Project#1008630 Manzano Mesa Tract(s) C
13DRB-70741 Preliminary/Final Plat Approval

9. **Project# 1008630**
13DRB-70682 MINOR - PRELIMINARY/
FINAL PLAT APPROVAL

RE: Tract C, Manzano Mesa

TRACT C-A
A REPLAT OF TRACT C AND VACATION OF
PORTION OF JUAN TABO BOULEVARD SE
MANZANO MESA
WITHIN SECTIONS 27 AND 28,
T. 10 N., R. 4 E., N. M. P. M.
CITY OF ALBUQUERQUE
BERNALILLO COUNTY, NEW MEXICO
DECEMBER, 2010

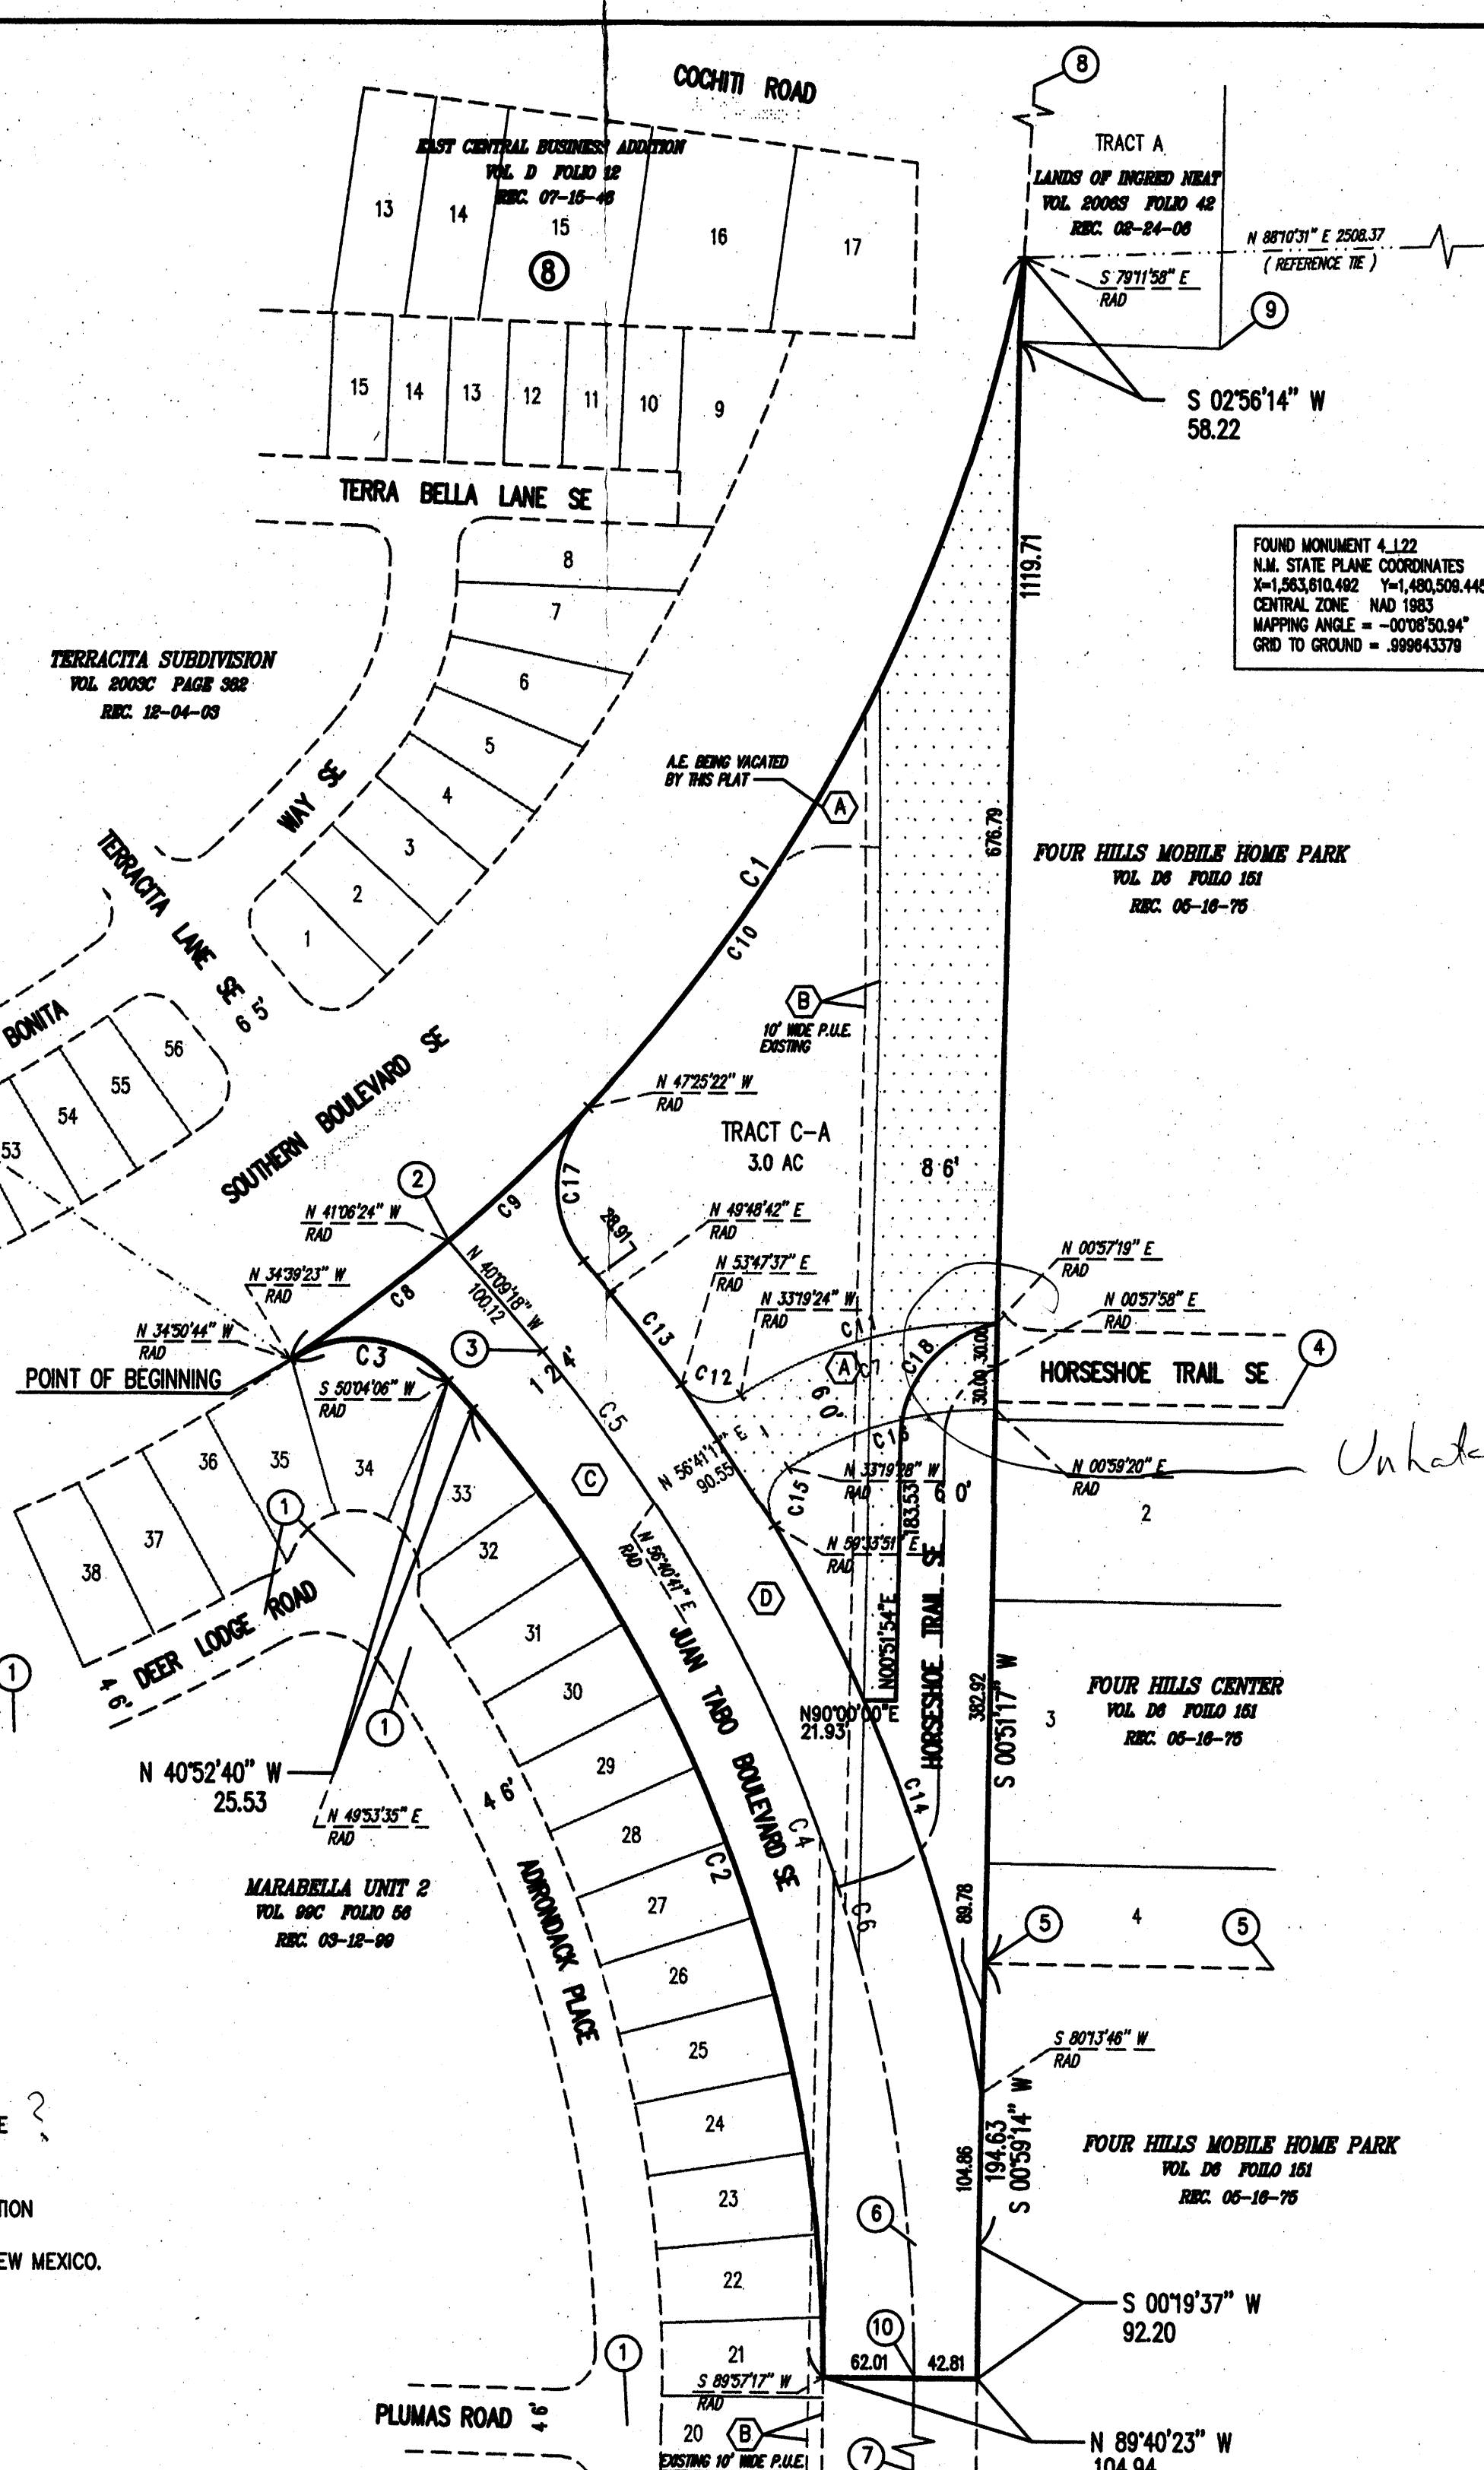
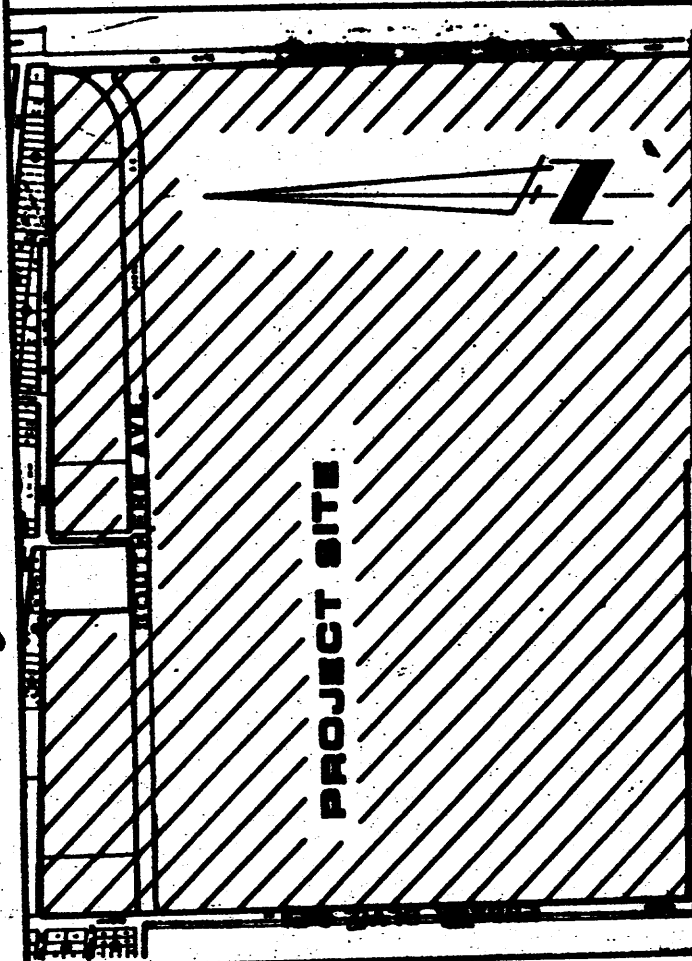
Why is the adjacent 10 foot Public Utility Easement not proposed for vacation?

Note 5 needs to be updated to reference ABCWUA, as does the signature block. A solar access note consistent with § 14-14-4-7 of the Subdivision Ordinance needs to be on the plat.

Plat boundary needs to be clear RE: centerline of new Juan Tabo Boulevard (refer to current plat - the 'west' half was dedicated via Marabella Unit 2 Subdivision).

It appears there is some hatching over the new connection for Horseshoe Trail that needs to be removed.
